<b>Application Ref:</b>	3/2026/0331			 Ribble Valley Borough Council <a href="http://www.ribblevalley.gov.uk">www.ribblevalley.gov.uk</a>				
<b>Date Inspected:</b>	N/A	<b>Site Notice:</b>	N/A					
<b>Officer:</b>	AR							
<b>DELEGATED ITEM FILE REPORT:</b>					<b>Refusal</b>

<b>Development Description:</b>	Certificate of lawfulness for proposed single storey rear extension.
<b>Site Address/Location:</b>	11 Spout Lane Longridge PR3 3BZ

PROPOSED SITE PLAN

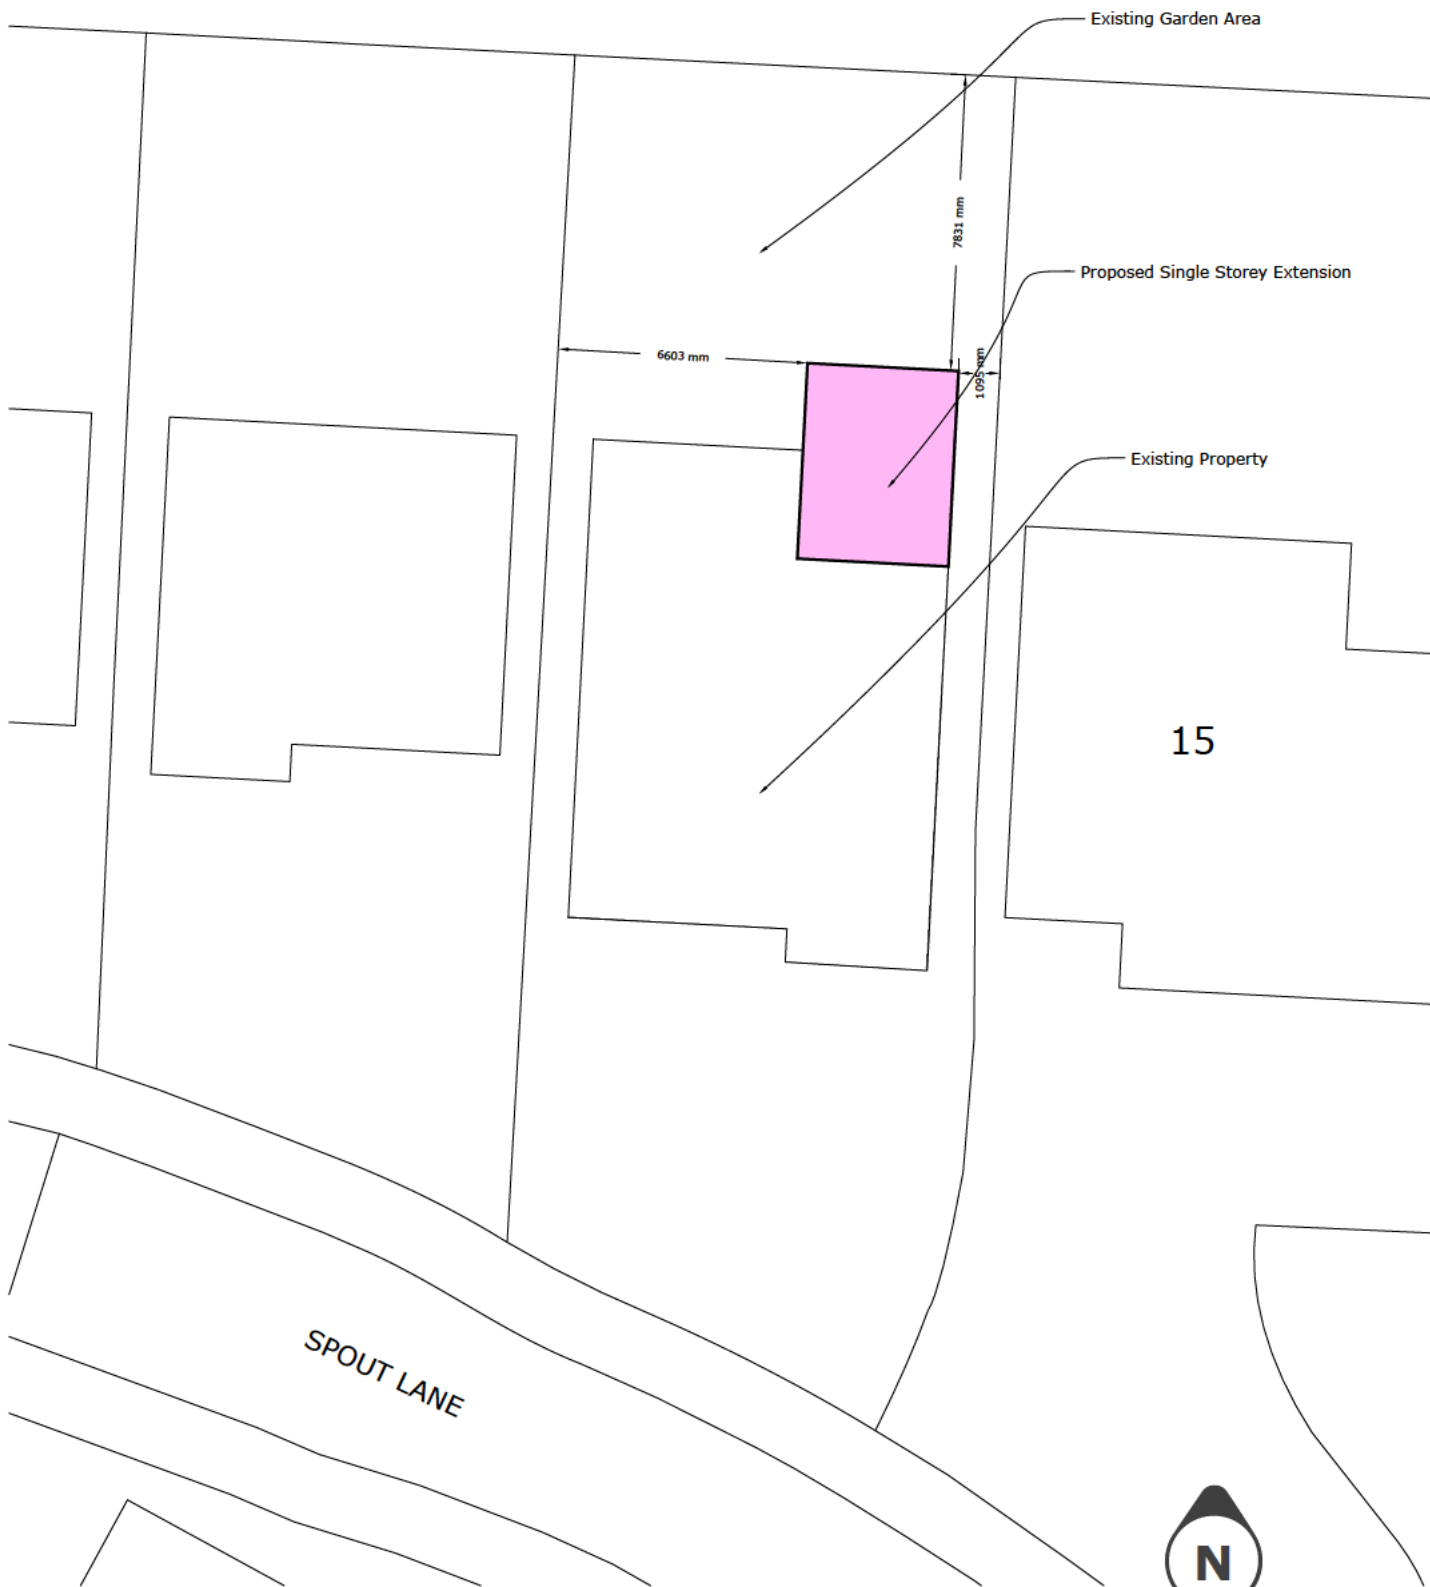
Consent is sought for the erection of a single-storey extension that projects out from the dwellinghouse's rear elevation by 5.1m with a width of 4.3m, and a flat roof with a maximum height of 2.7m.

**The proposed extension would have a single storey and would extend beyond the rear wall of the original dwelling house by more than 4 metres.**

The proposed works are not deemed to be Permitted Development by virtue of Class A, Part 1, Schedule 2, A.1(F) of The Town and Country Planning (General Permitted Development) (England) Order 2015, insofar that the enlarged part of the dwellinghouse would have a single storey and would extend beyond the rear wall of the original dwelling house by more than 4 meters in the case of a detached dwelling house.
---
